Rezoning Petition Review

Date of Review: August 21, 2017 (***Revised January 13, 2021***)

Rezoning Petition #: 17-118

Location of Property: Approximately 0.78 acres located at the northwest corner at the intersection of Statesville Road and Cindy Lane.

DATE: 01/11/21
FILE: M21014
DRAWN BY: RST
REVISED:
JOB NO: _____
SHEET: RZ-1
OF: _____

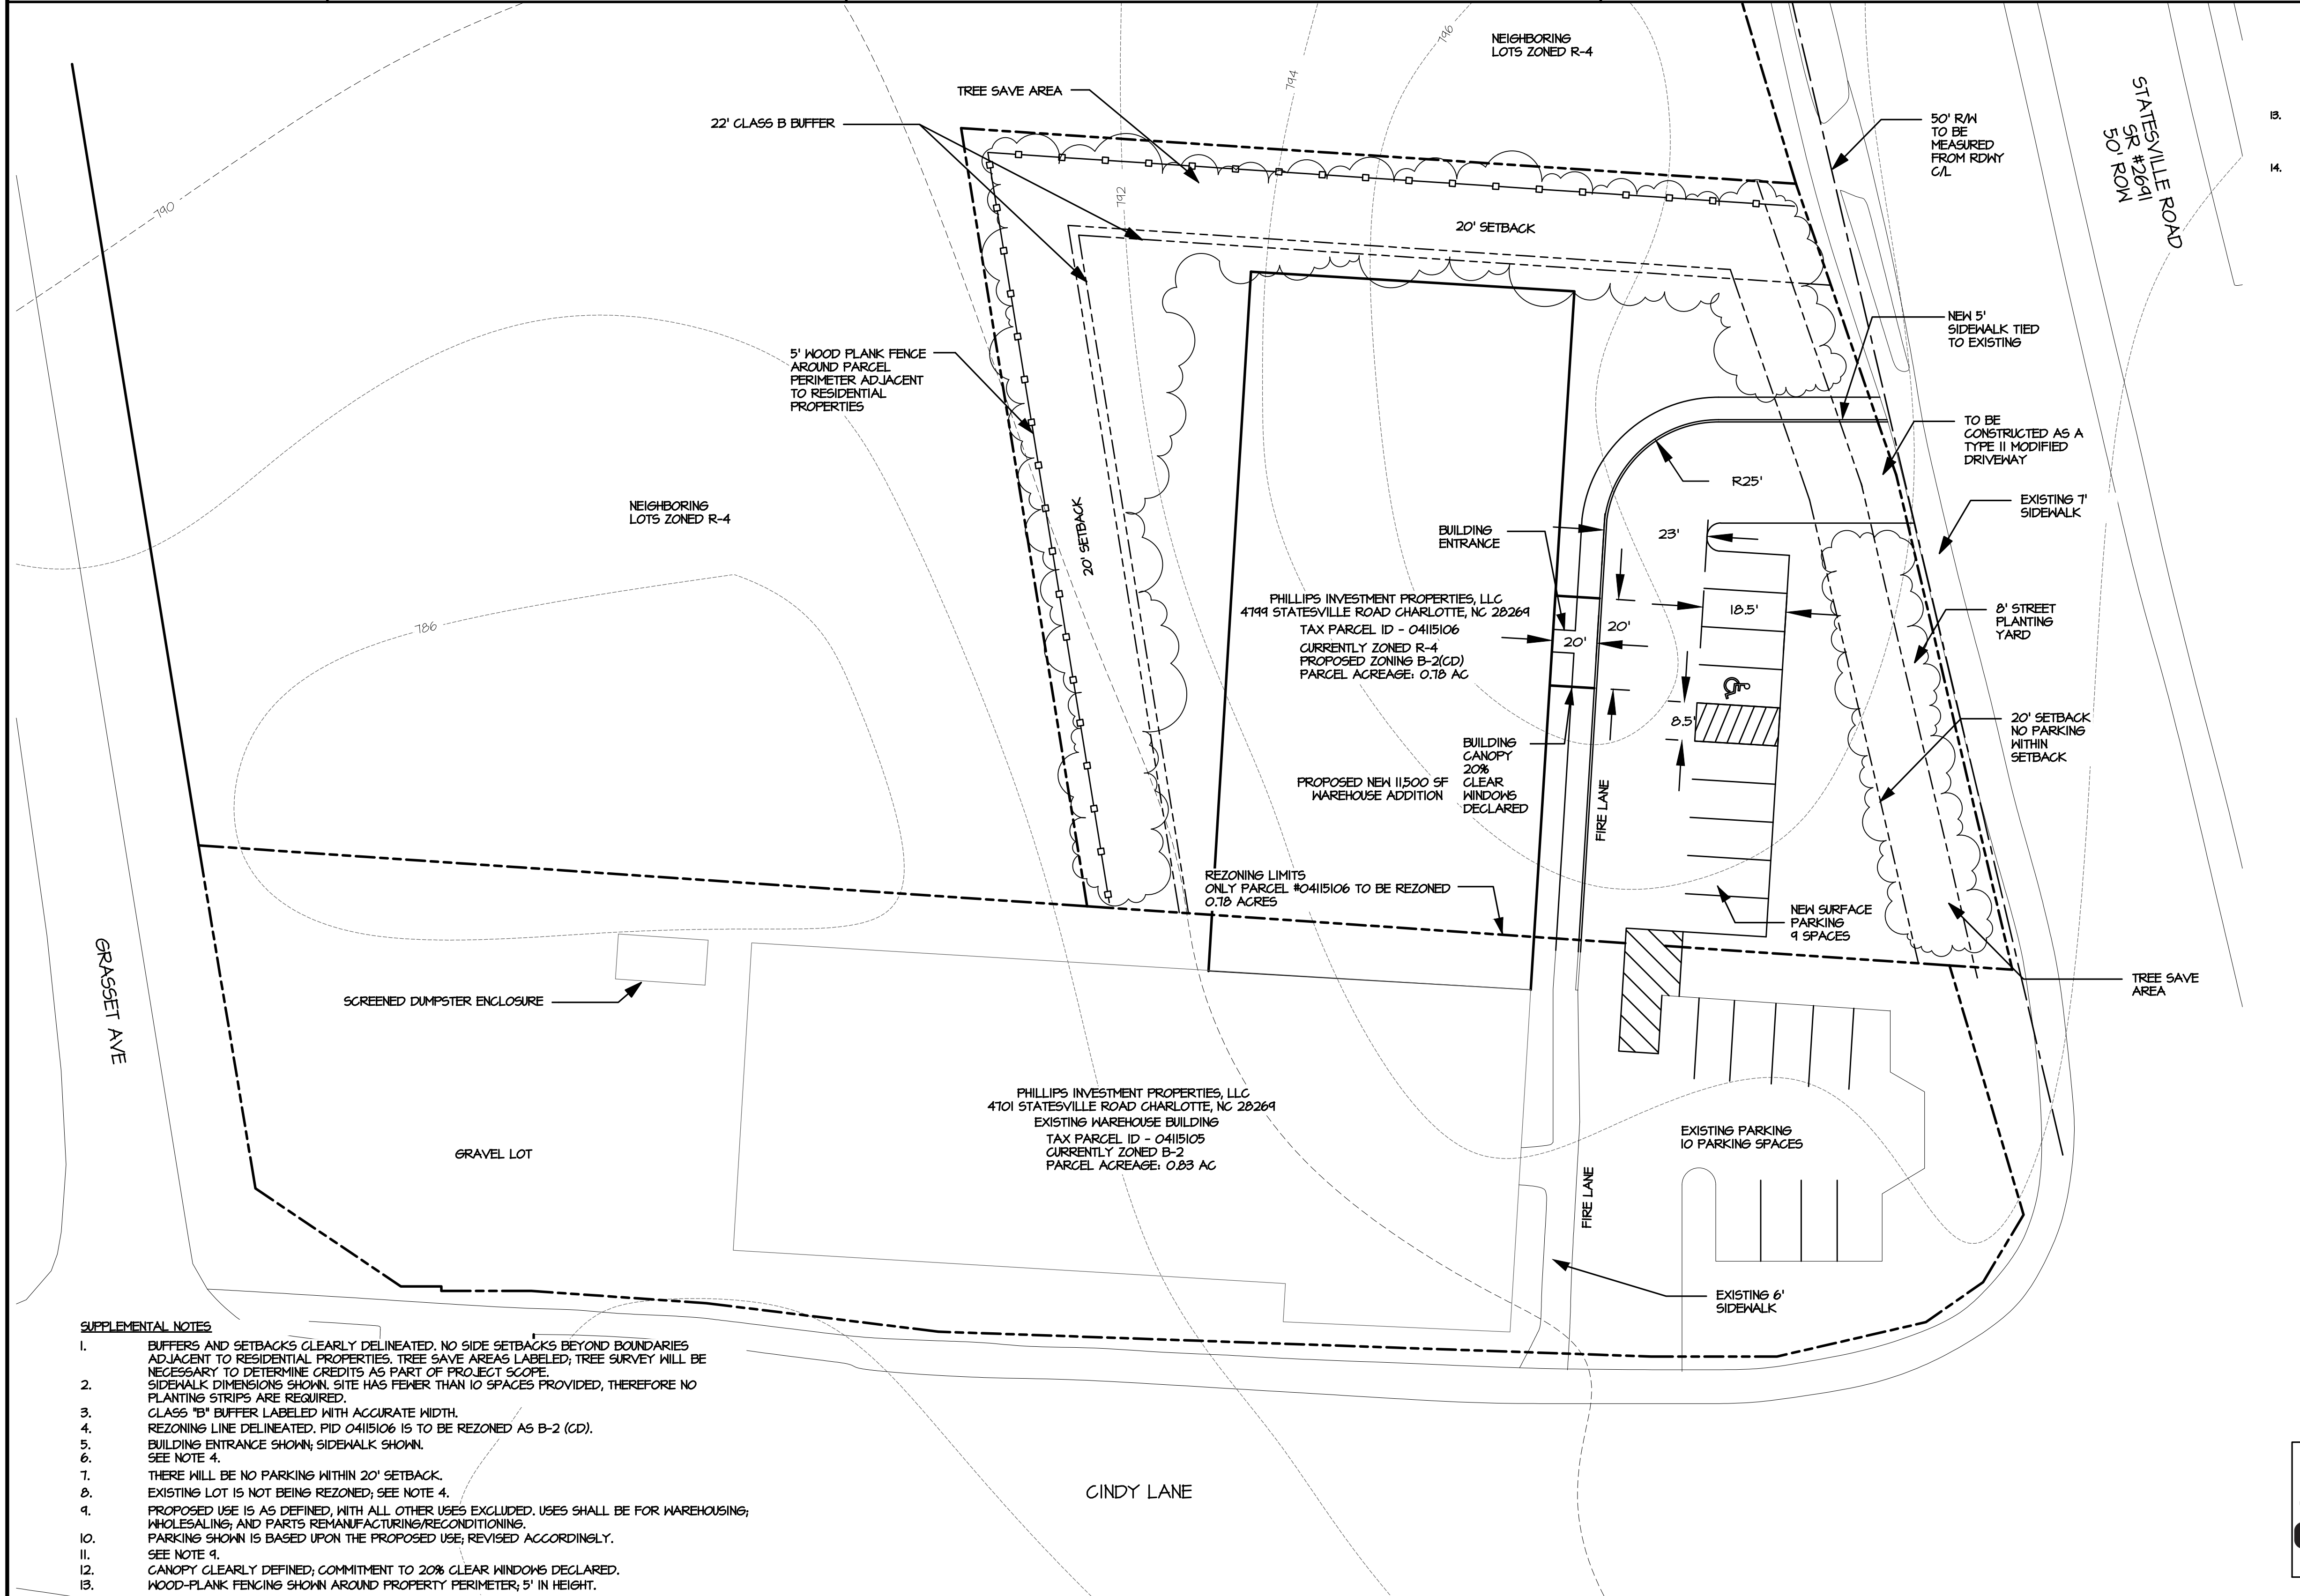
Concerning Storm Water: Please remove note 8b in its entirety and replace with the following:
"The petitioner shall comply with the Charlotte City Council approved and adopted Post Construction Stormwater Ordinance."

Due to revisions (1/13/21): Post Construction Stormwater Ordinance applicability is determined during the Land Development plan submittal and review process, and not during the rezoning request process and approval.

Please remove note 8b in its entirety and replace with the following:
"The petitioner shall comply with the Charlotte City Council approved and adopted Post Construction Stormwater Ordinance."
